Road Safety Audit

Designer's Response

The Demolition of 'The Steddles' North End Road, Yapton and erection of 11 New Dwellings

Rev P1 – 24th Sept 2021

Title Drainage GA

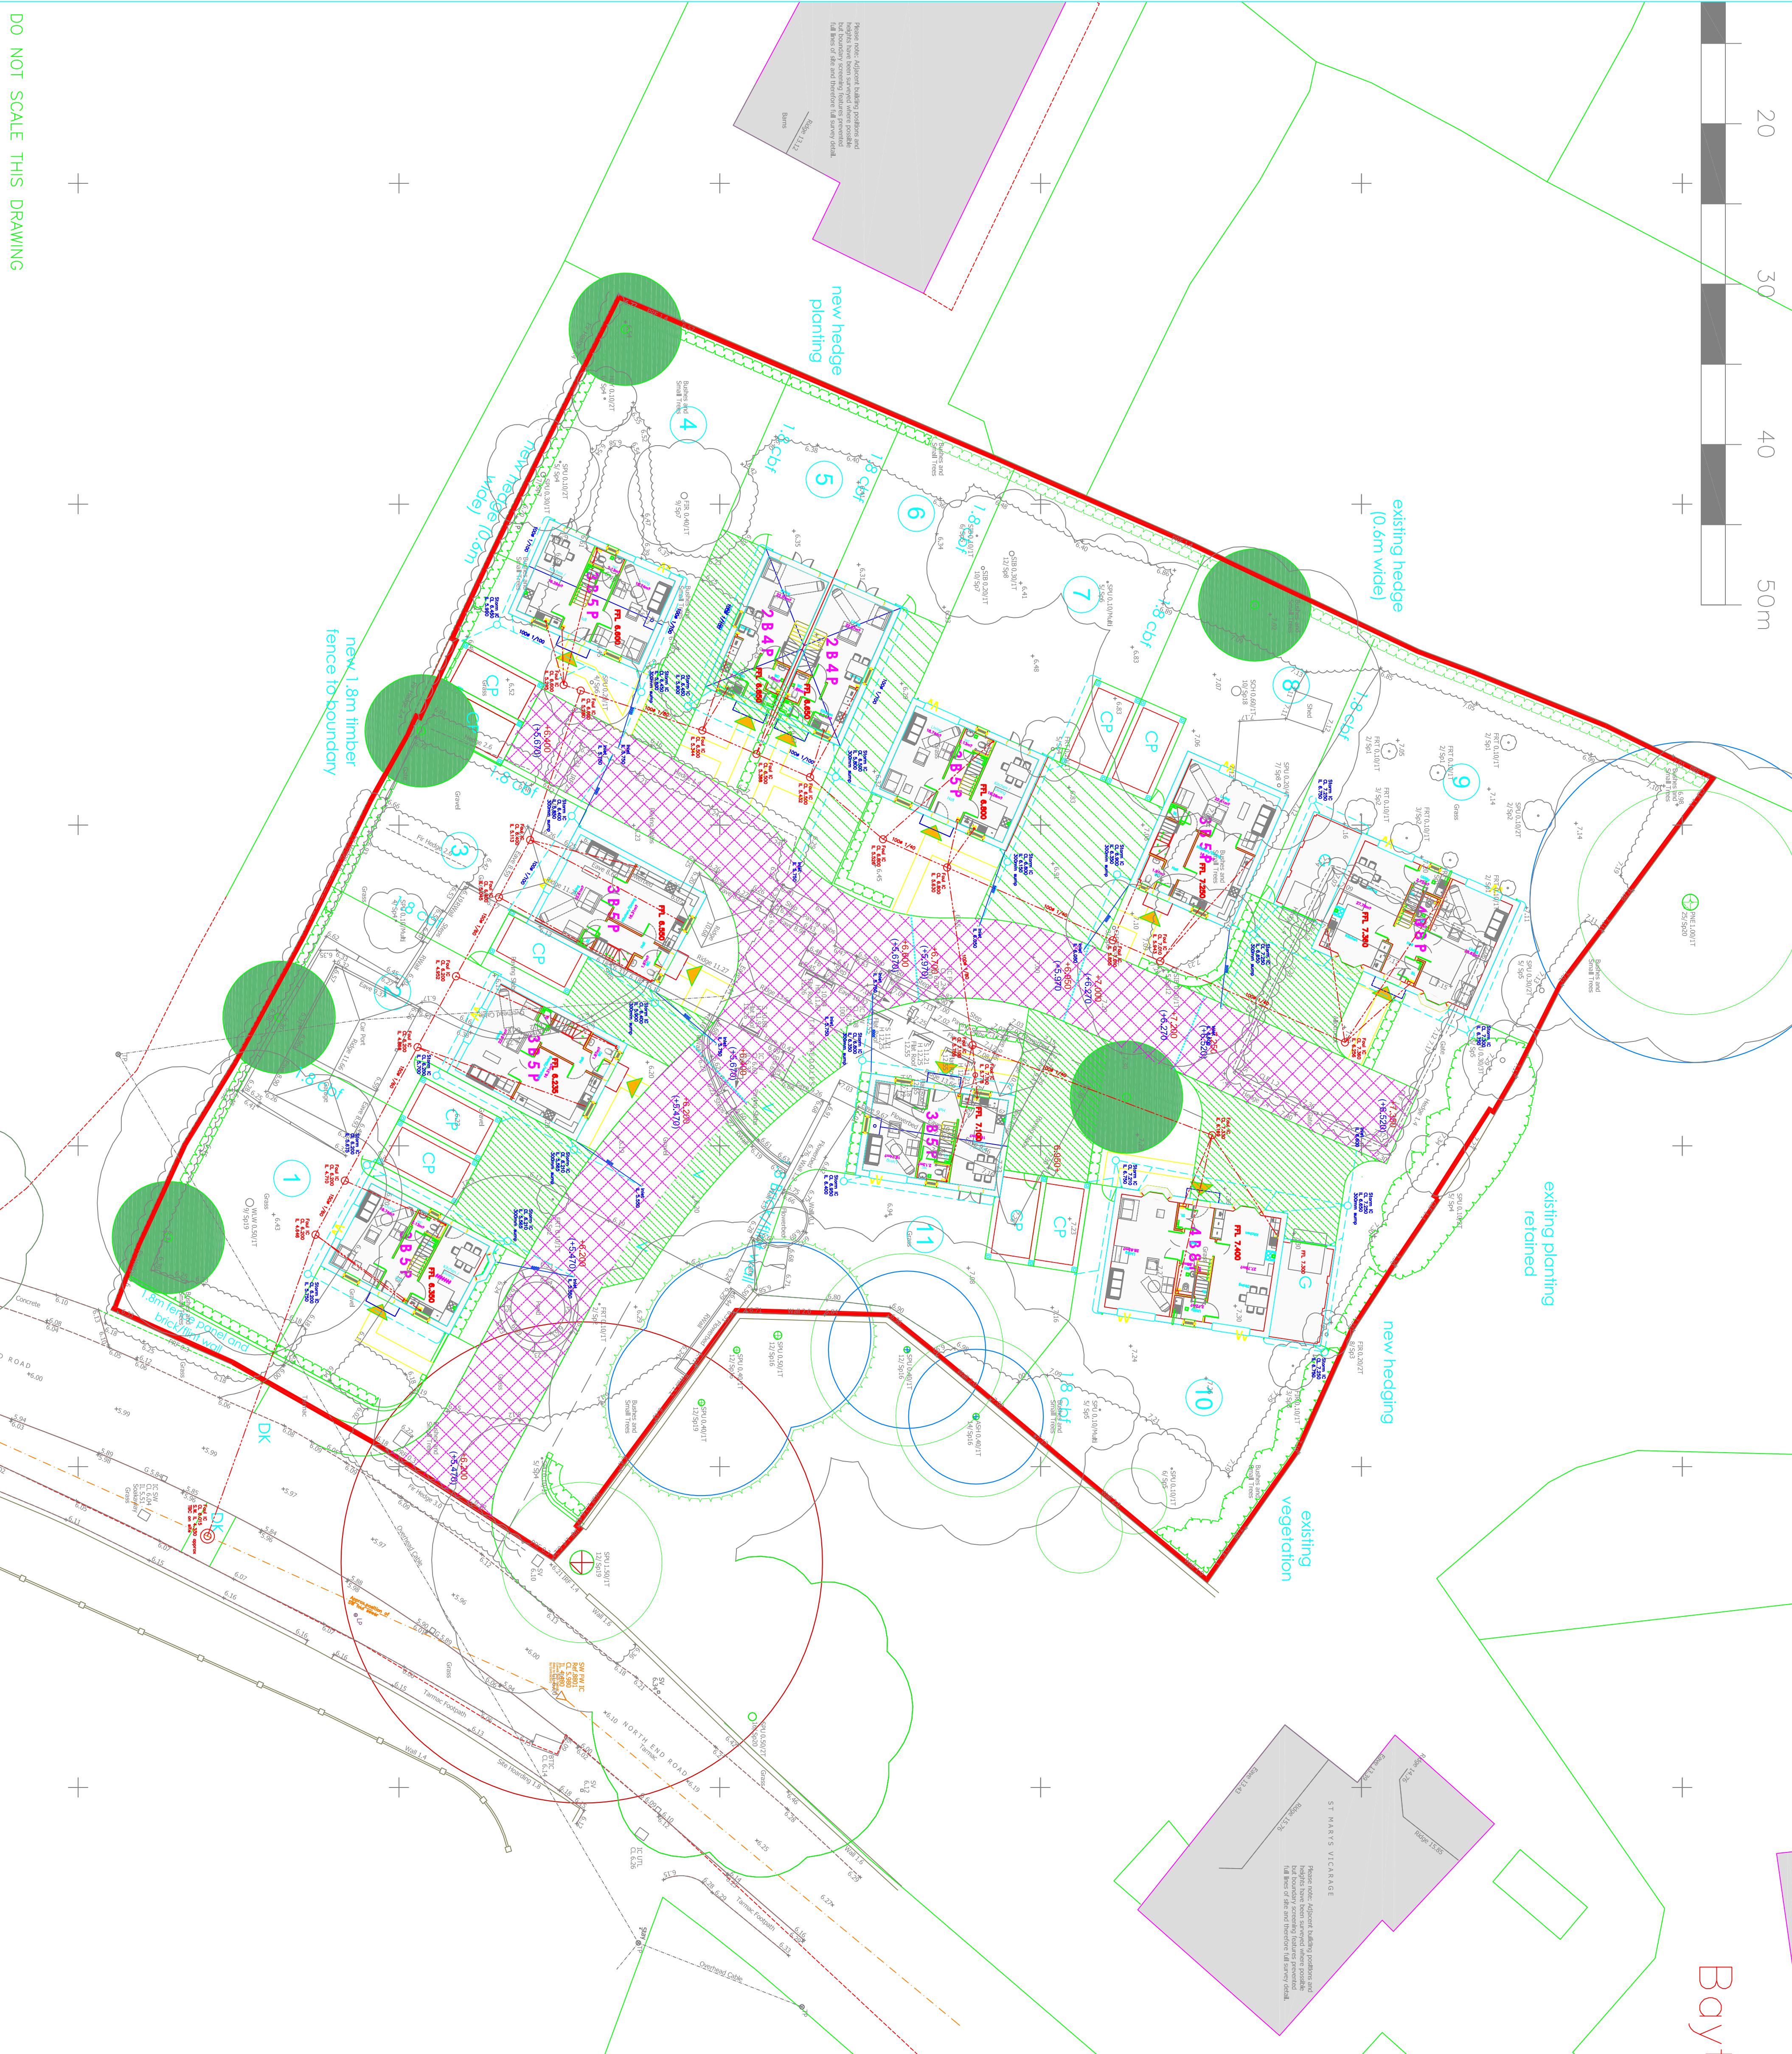
Item.	RSA Problem	RSA Recommendation	Designer Organisation Response	Overseeing Organisation's Response	Agreed RSA Action
3.1.1	New kerblines are being introduced, where no details of carriageway drainage or carriageway vertical profiles have been provided for assessment. North End Road appears to be super elevated on the bend or where water moving across the carriageway or ponding on the carriageway could lead to loss of control collisions	It is recommended that drainage details should be provided at Safety Audit Stage 2, or that the carriageway should be shaped so that the highway drains	The new junction design for the development will be the subject of a Section 278 Agreement with WSCC. Liaison with WSCC on the detailed design will include a Stage 2 RSA, and would be expected to address any issues affecting drainage/ponding that are directly related to the proposed development	Agree that details should be provided at detailed design / Stage2 RSA.
